**WELWYN HATFIELD COUNCIL – DEVELOPMENT CONTROL**  
**DELEGATED REPORT**

<b>APPLICATION No:</b>	<b>S6/2009/0772/FP</b>
------------------------	------------------------

This application seeks full planning permission for a two storey side extension, single storey rear and single storey front between the existing lobby area and the neighbours garage.

# 1 & 2 STOREY EXTENSION at 2, De HAVILLAND CLOSE, HATFIELD.

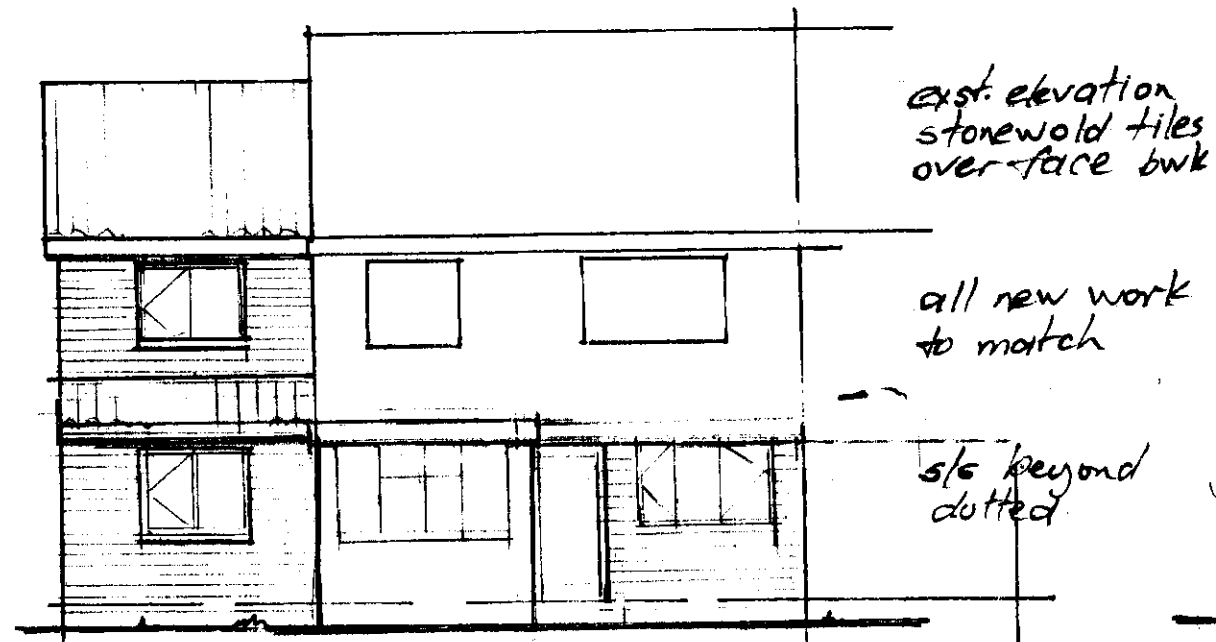
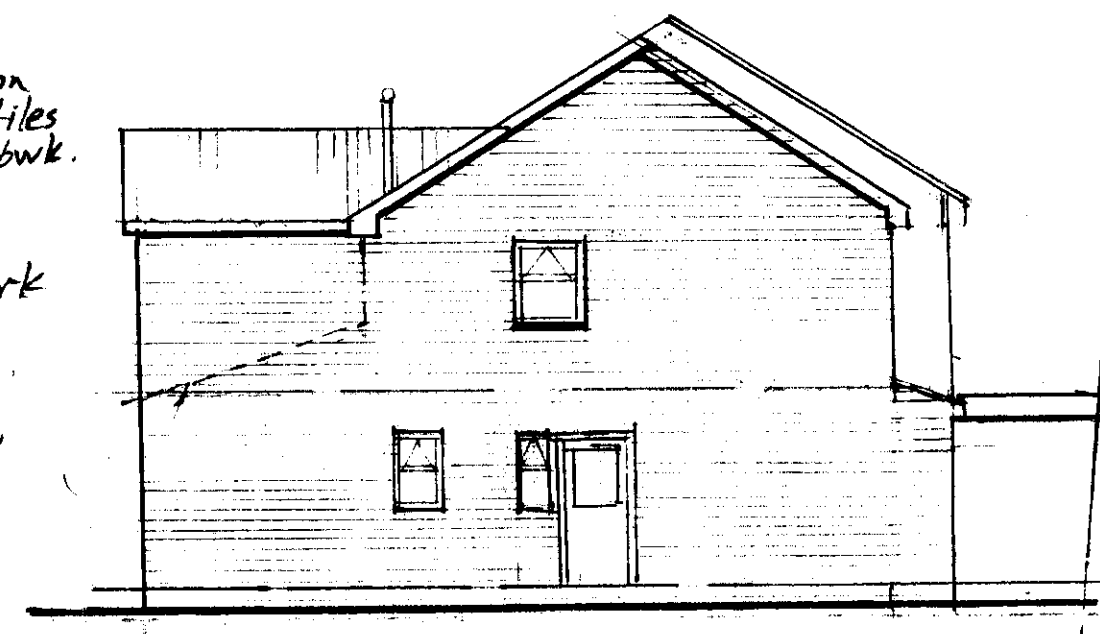
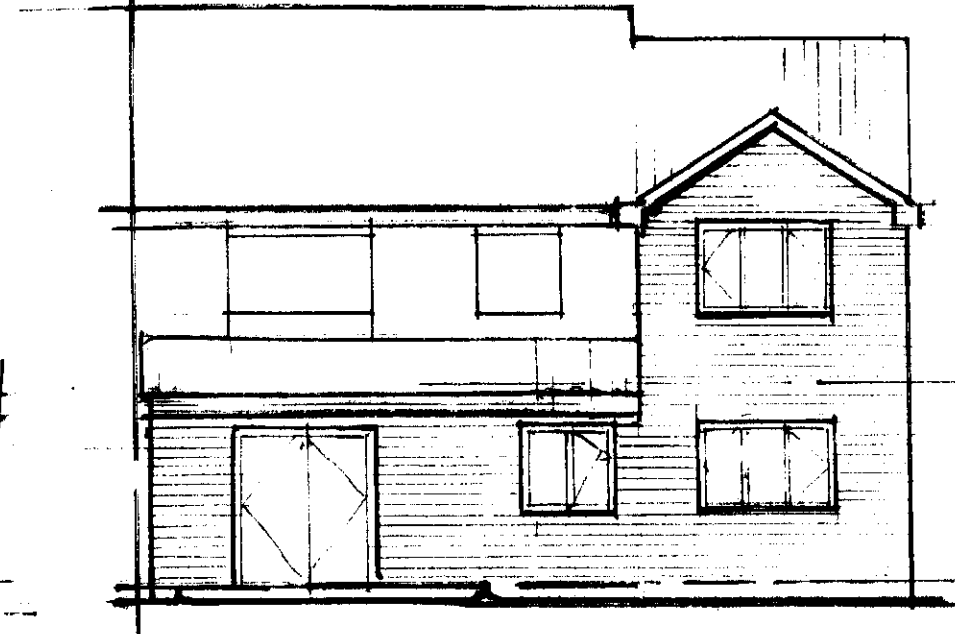
The proposal would add development to each of the three elevations. The front extensions would each have small hipped roofs. This is not a characteristic of the area, where extensions are finished with flat roofs. Discussion with the agent has resulted in amended plans for the hipped roof between the neighbours garage and lobby. The hipped roof to the side extension has not been removed. This however, is very modest in size, would be set behind the front elevation of the existing dwelling and would therefore have minimal impact and thus is acceptable.

---to flank

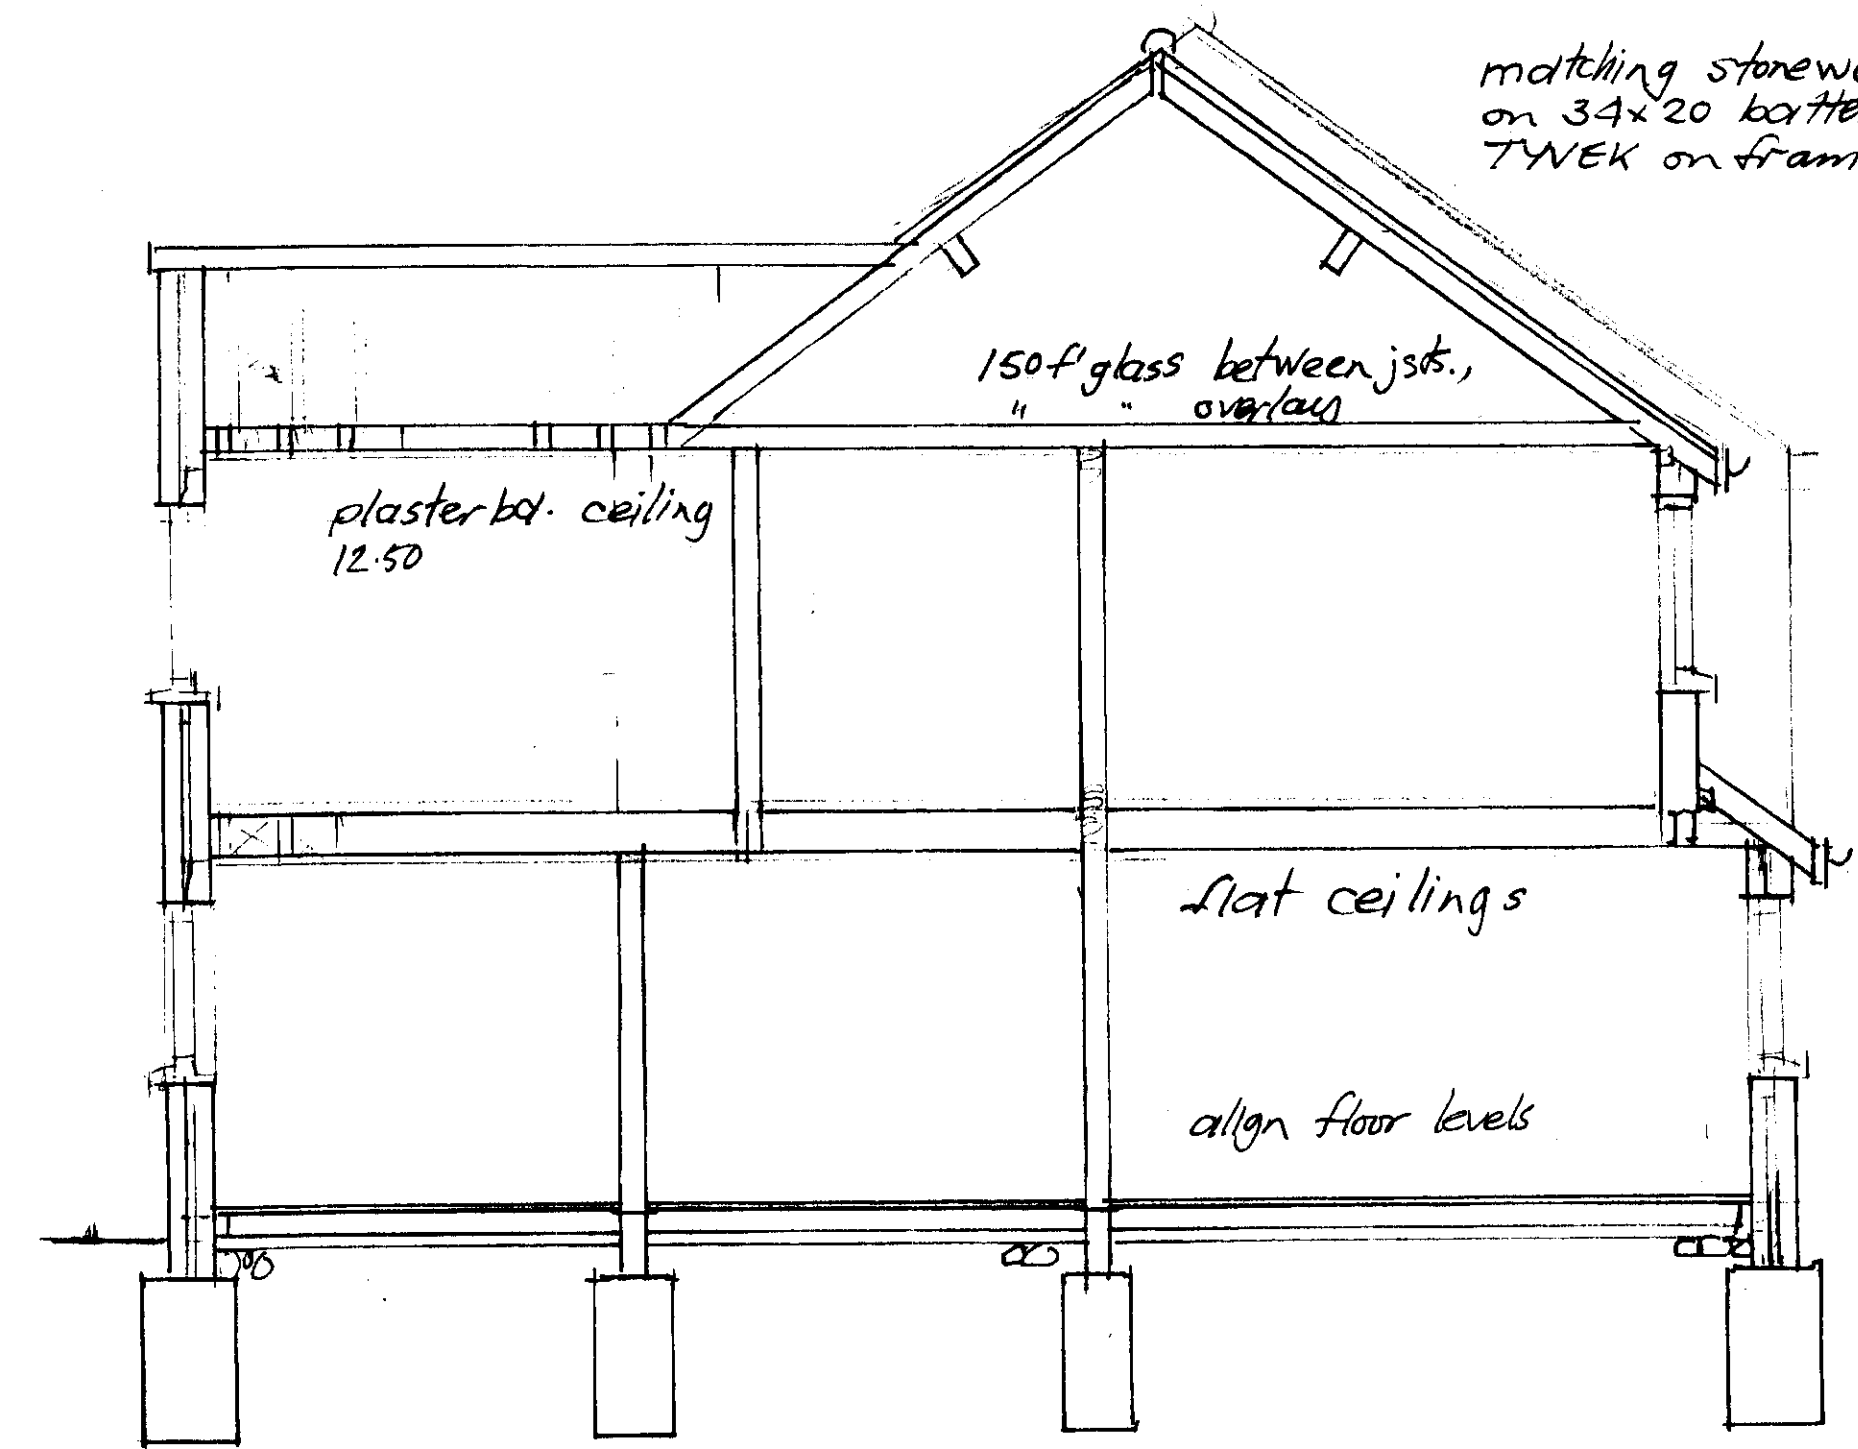
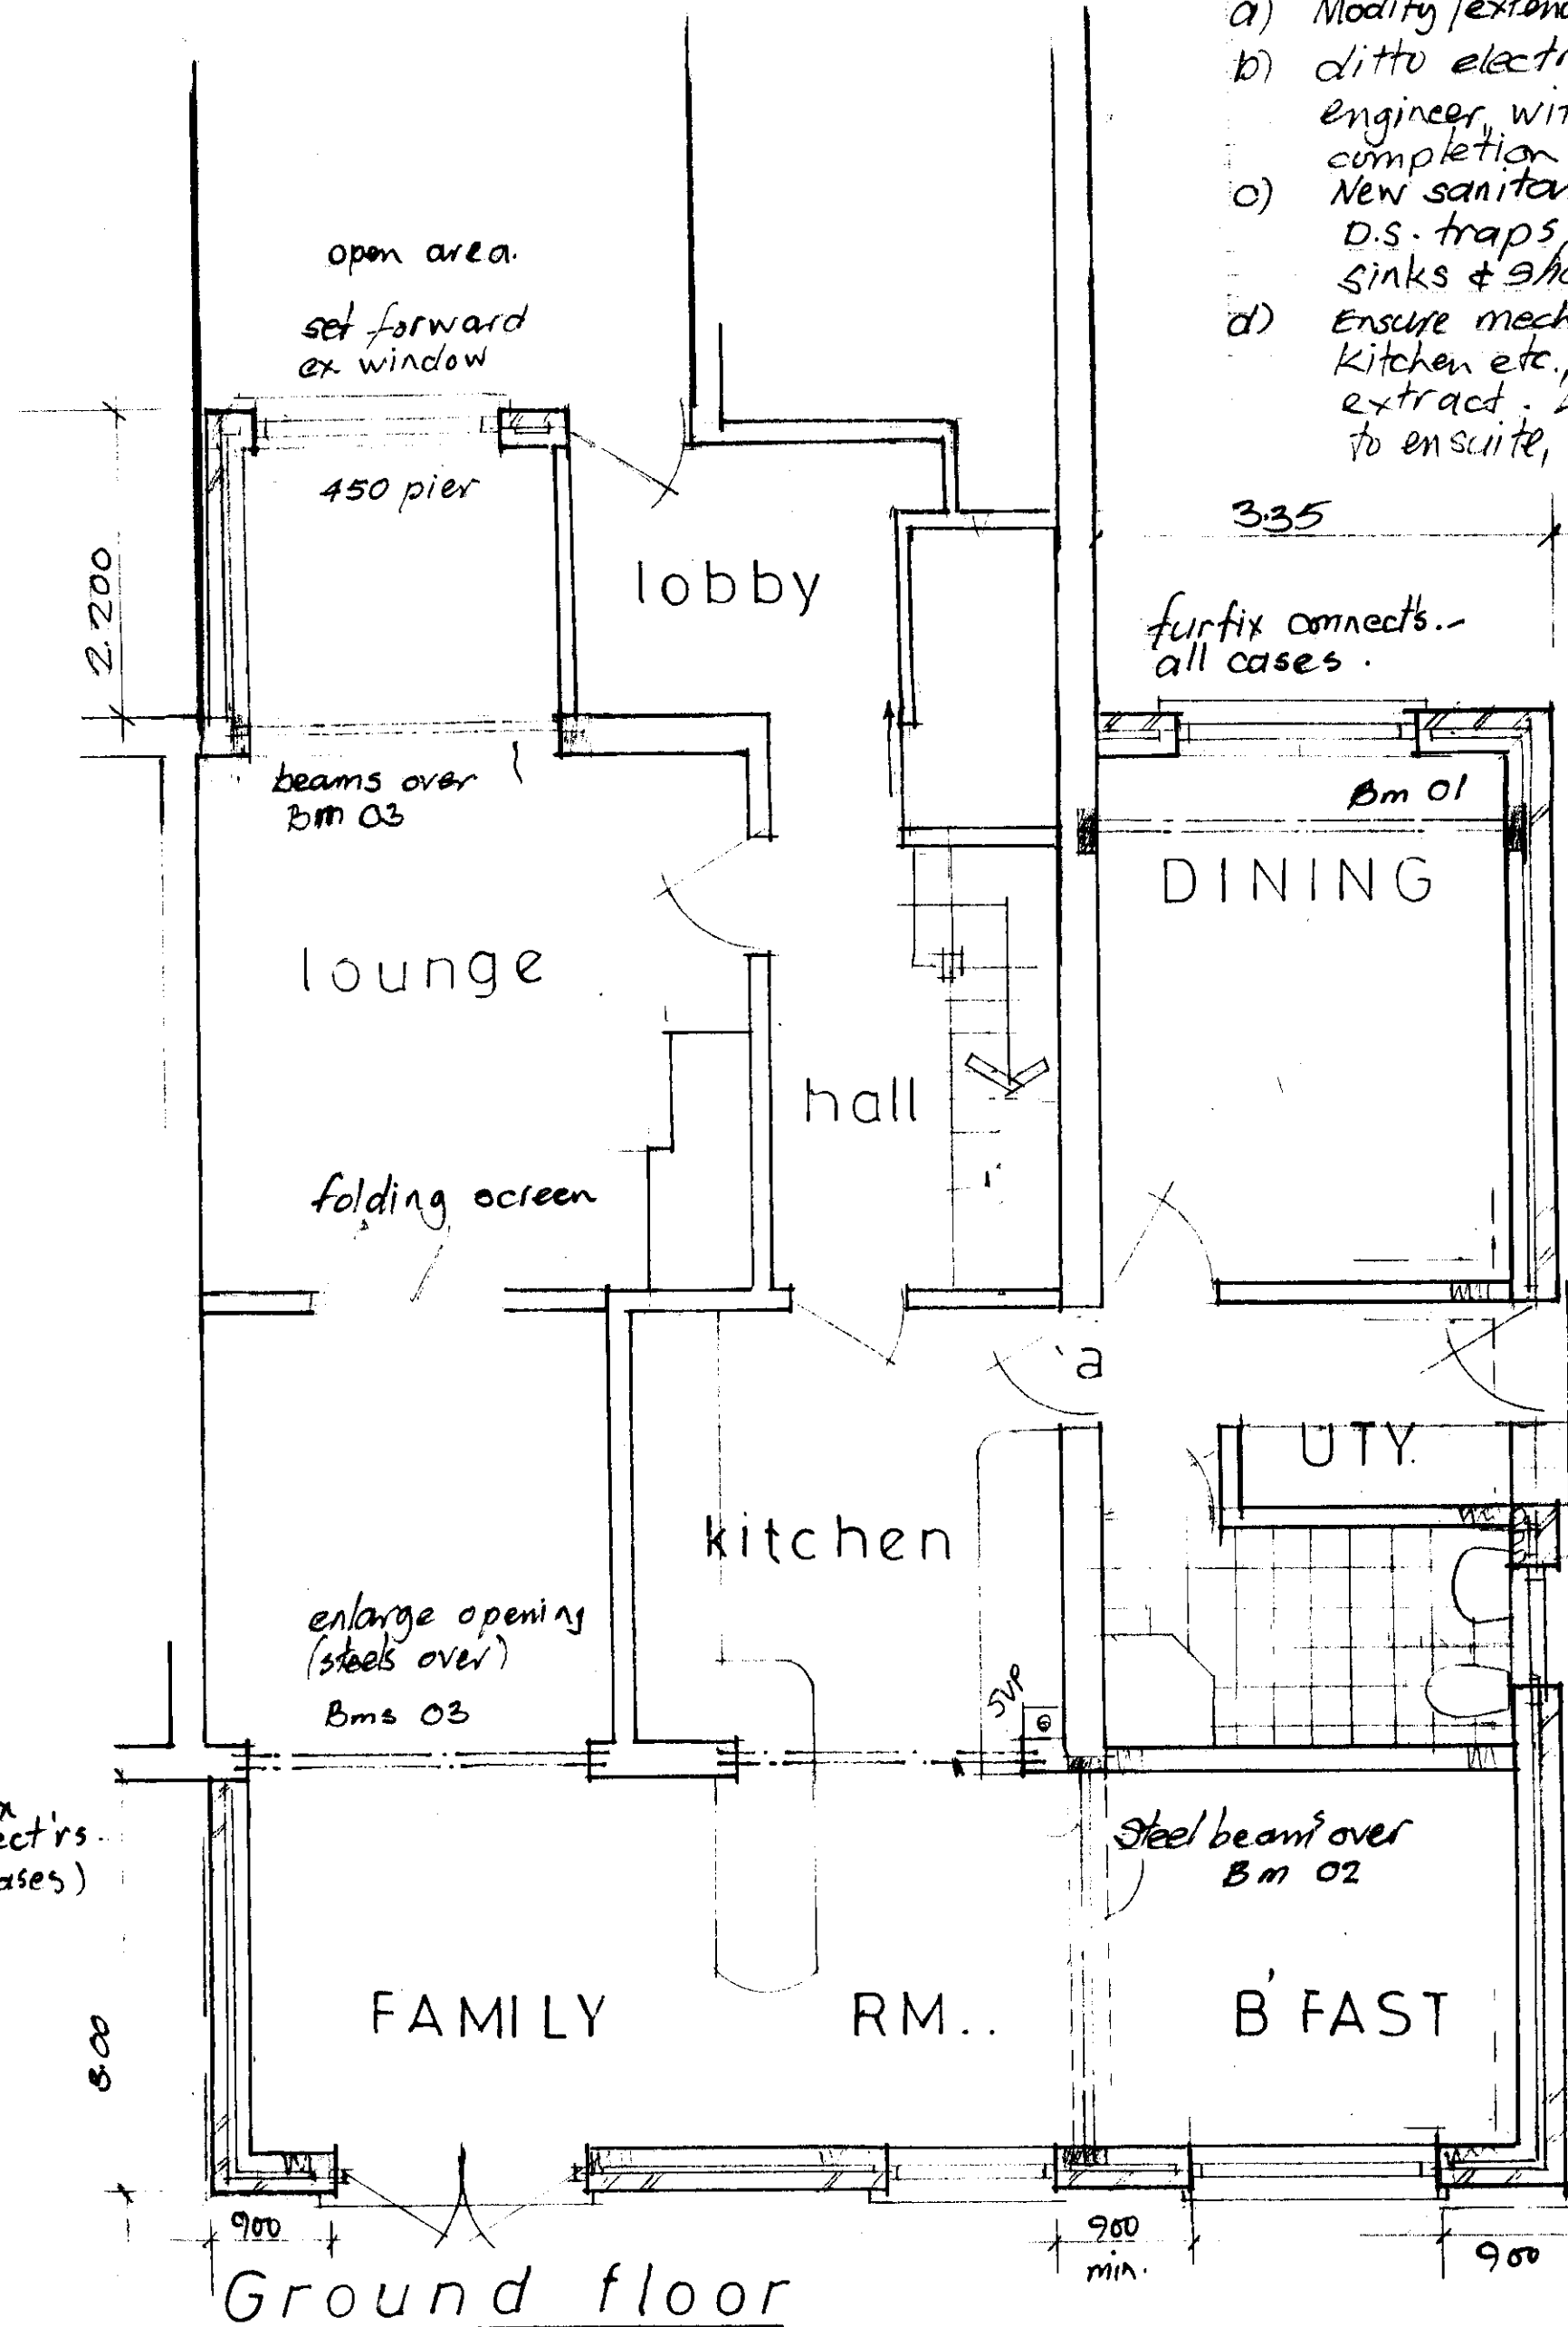
A neighbour in the adjoining block of flats has objected due to the possibility of overlooking to and from the development. Windows are proposed in the flank elevations at both ground (2 windows) and first floor (1 window). The window at first floor is to a bathroom and shown to be obscured. The downstairs is to a toilet and utility room/entrance doorway. The toilet would again be likely to be obscured. However it would not be unreasonable to include a condition requiring these windows/doors to be obscured.

1. C.2.1 – time Limit
2. C.13.1: Development in accordance with approved plans/details received and dated
3. C.5.2 – matching materials
4. C.7.9 – obscured glazing (windows and doors of the flank elevation)
